KITITAS COUNTY

MEMORANDUM

TO: All Staff
FROM: Justin Turnbull, County Surveyor 
DATE: December 21, 2020
SUBJECT: County Survey Review of BL-20-00027 Kelly (CDS refers to this as Pine View Estates)

BOUNDARY LINE ADJUSTMENT BL-20-00027
 PREPARED FOR
 KEVIN KELLY
 A PORTION OF THE EAST 1/2 OF SECTION 6,
 TOWNSHIP 19 NORTH, RANGE 16 EAST, W.M.
 KITITAS COUNTY - WASHINGTON

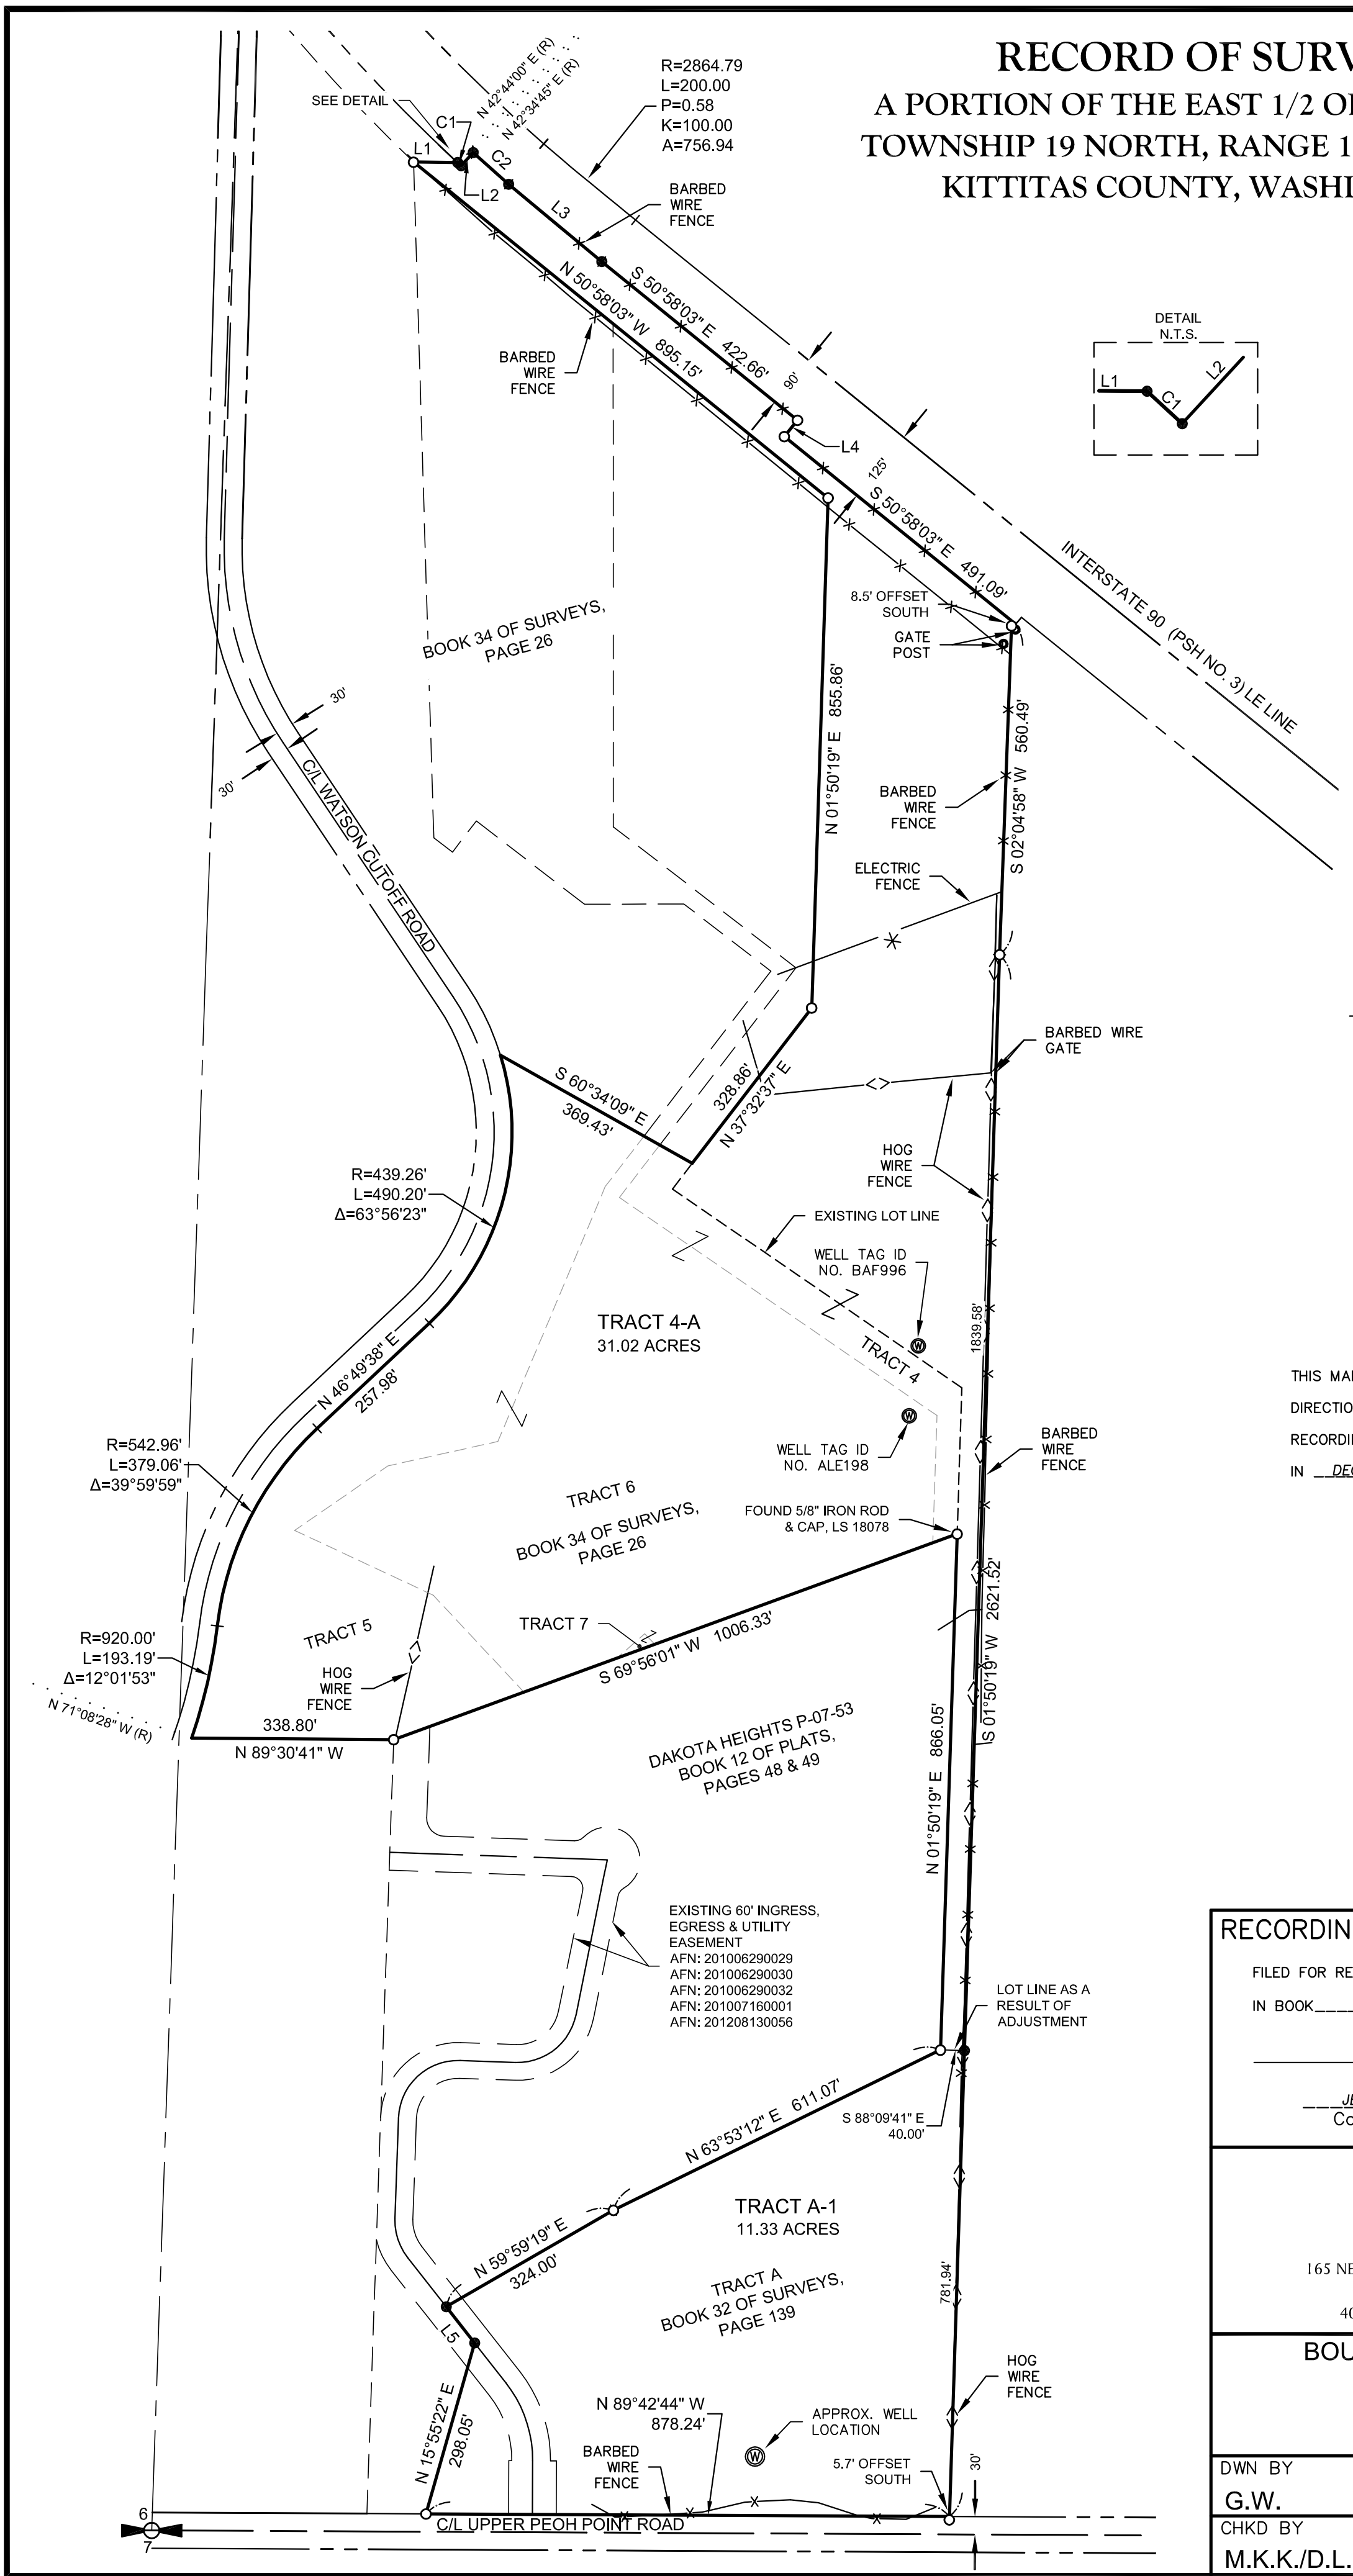
While the Section corner shown would require a tie to the survey per RCW/WAC, it is clear that this is shown purely as reference and is not part of the control network for the survey. As such, there would be no benefit in including a tie to this corner.
